KIRKLEES METROPOLITAN COUNCIL INVESTMENT & REGENERATION SERVICE

DELEGATED DECISION TO DETERMINE PLANNING APPLICATIONS

Reference No: 2021/62/90900/E

Description: Erection of single storey and two storey extensions, dormer windows to front and rear and Juliet balcony's to front and rear

Proposed East Elevation.Scale 1:100

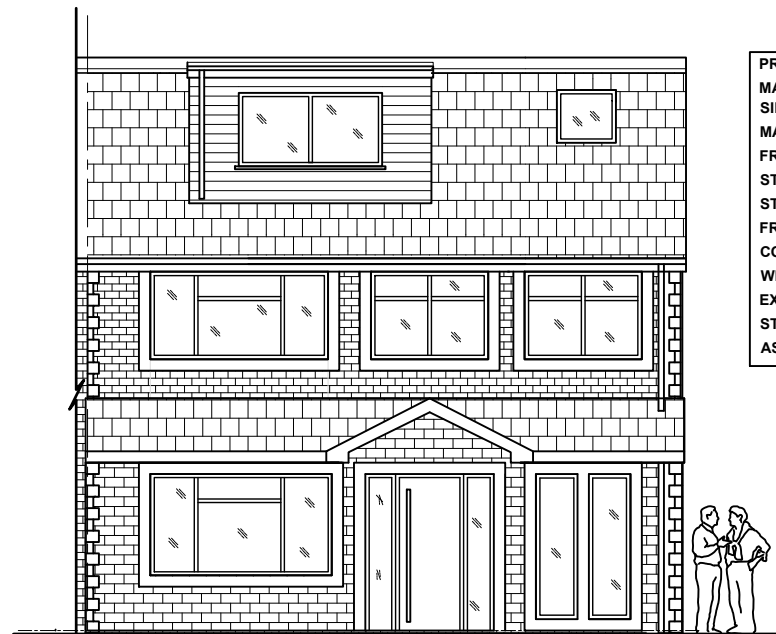
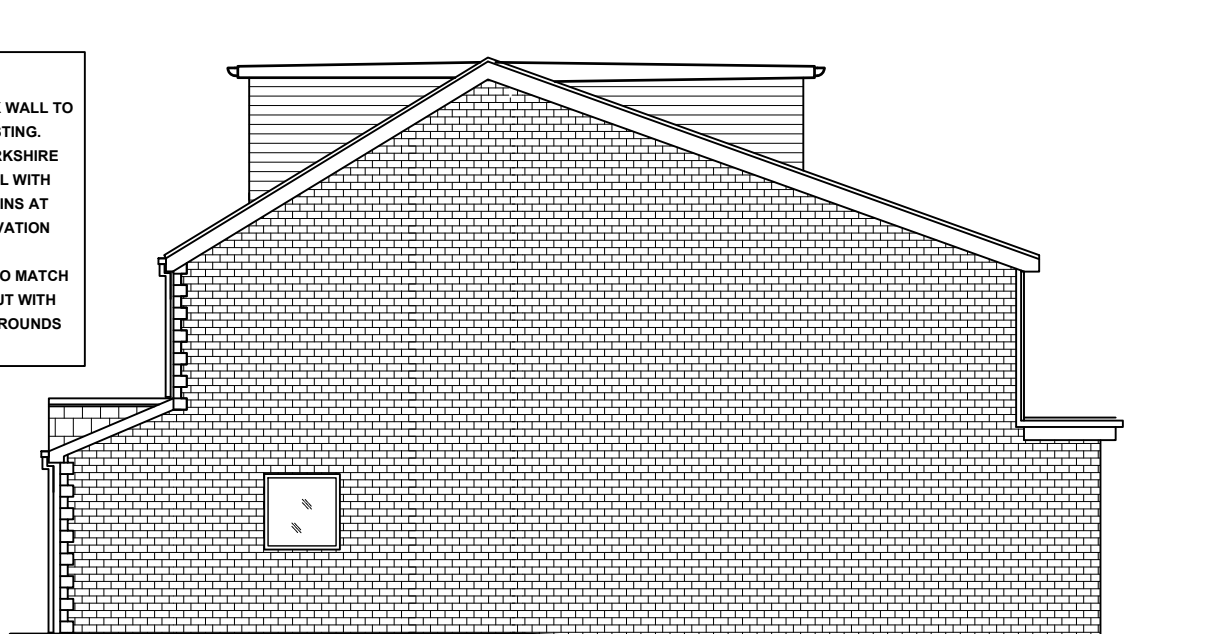
The submitted plans raised significant concerns in terms of design of the front extension given the initially proposed flat roof form and balcony. The Kirklees Development Management Charter together with the National Planning Policy Framework and the DMPO 2015 encourages negotiation/engagement between Local Planning Authorities and agents/applicants. As such, amended plans were sought and received to amend the roof design of the front extension to overcome the concerns. As the alteration was minor and did not substantially increase the scale of the development, the amended plans have not been advertised.

The limited scale and single storey nature of the front extension together with the use of matching materials is such that the front extension can be considered acceptable in terms of visual amenity.

The submitted plans raised significant concerns in terms of design of the front extension, given the initially proposed flat roof form and balcony. The Kirklees Development Management Charter together with the National Planning Policy Framework and the DMPO 2015 encourages negotiation/engagement between Local Planning Authorities and agents/applicants. As such, amended plans were sought and received to amend the roof design of the front extension to overcome the concerns. As the alteration was minor and did not substantially increase the scale of the development, the amended plans have not been advertised.

Proposed West Elevation.Scale 1:100

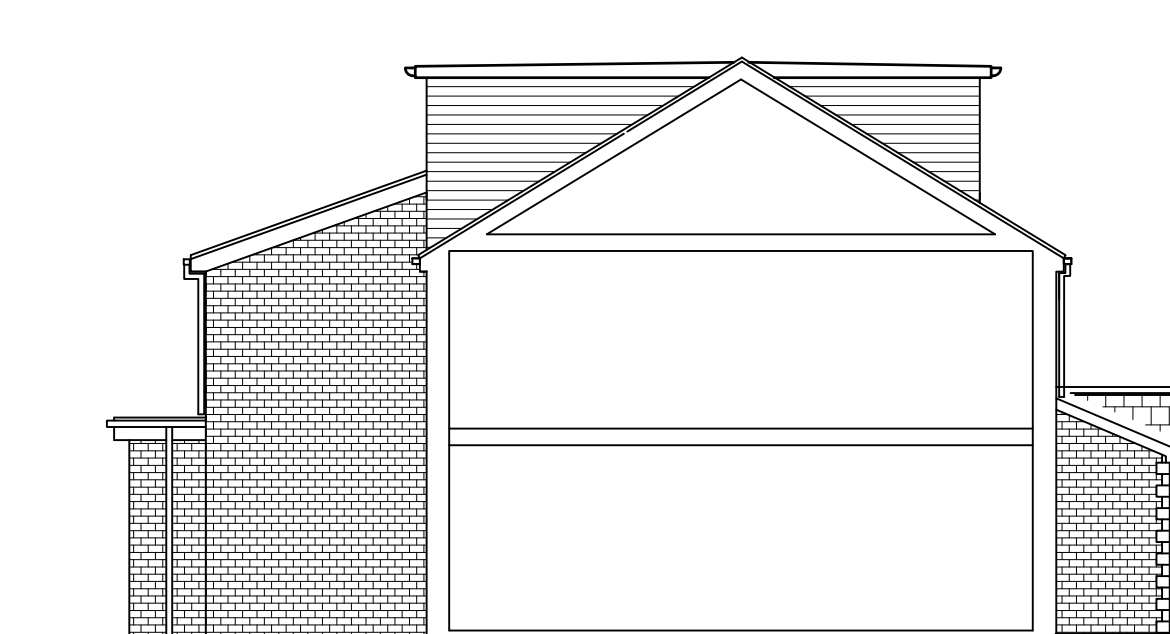
The works to the rear would not increase the footprint of the dwelling. The materials proposed would match the main house. The detailing including the use of a juliet balcony and the sloping roof would form an acceptable relationship with the main house. Indeed, there is a similar extension to the rear of 15 Harewood Avenue and as such this would not be out of character with the wider area. The first-floor rear extension is therefore considered to be acceptable in terms of visual amenity.

The rear dormer is a box like structure proposed within the roof plane. The design is clearly based on function rather than form and given the elevated position of the dwelling, there would be views of this from the road to the rear. However, there is a similar structure to the rear of 15 Harewood Avenue, and this would not be out of character with the wider area. It is also noted that there is a fall-back position to form a dormer under permitted development. As such and on balance the dormer is considered acceptable in terms of visual amenity.

The extension to the rear would reduce the space between the host property and the garden area of the neighbouring 33 Cawley Lane to approx. 17m. The oblique angling together with the land level difference would limit the impact the proposed first floor extension to the rear in terms of the amenities of the occupiers of the neighbouring 33 Cawley Lane.

This neighbour to the rear occupies a significantly lower position with an angled relationship relative to the host property. There is a separation of 22m however, the land level differences do exaggerate the relationship between the properties. The proposals would see the first floor extended further back. Although the projection is limited to 3m which would not have a significantly greater impact than the existing arrangements. It is noted that there would be a juliet balcony, which could give the perception that there would be increased overlooking. However, this is in effect a larger window in terms of its height with the lower sections offering no significant opportunity for overlooking. The angled relationship together with the separation are considered to off set the potential impacts of the extension with the elevated position of the host property.

Proposed Ground floor plan,Scale 1:100

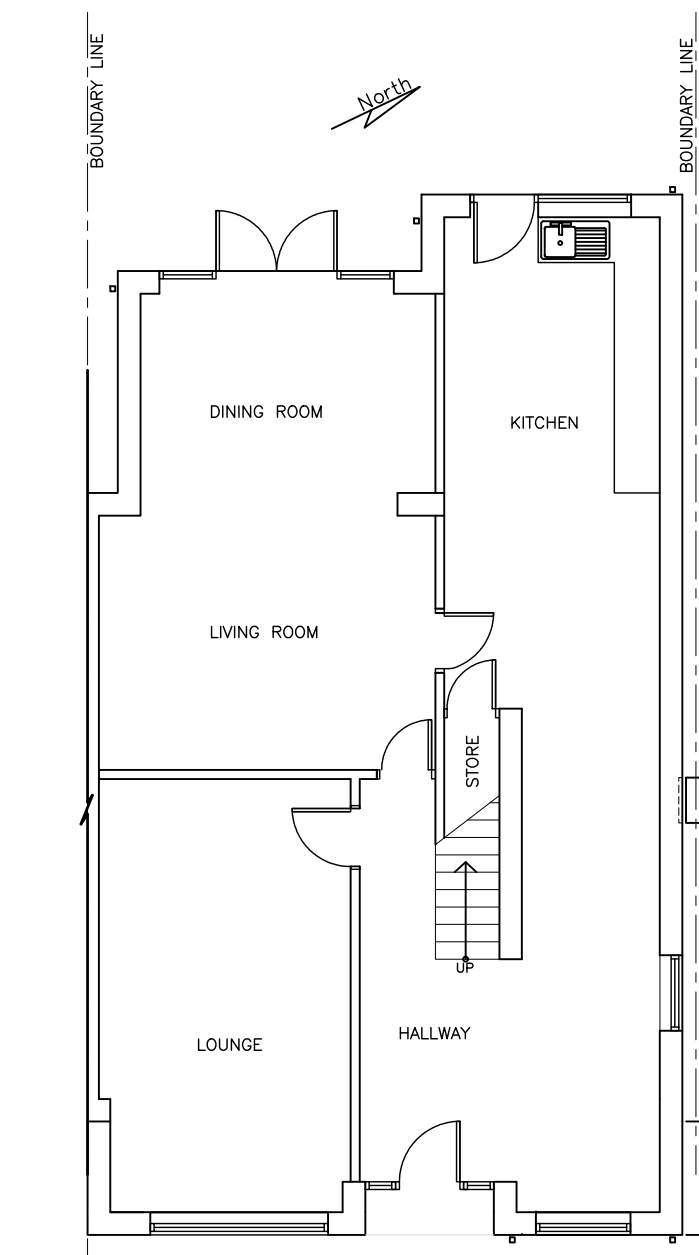
The front extension would project 1.5m from the original front wall of the dwelling extending across the width of the dwelling including to the front of the side extension. The roof form is proposed to be lean to with a pitched detail over the central front door.
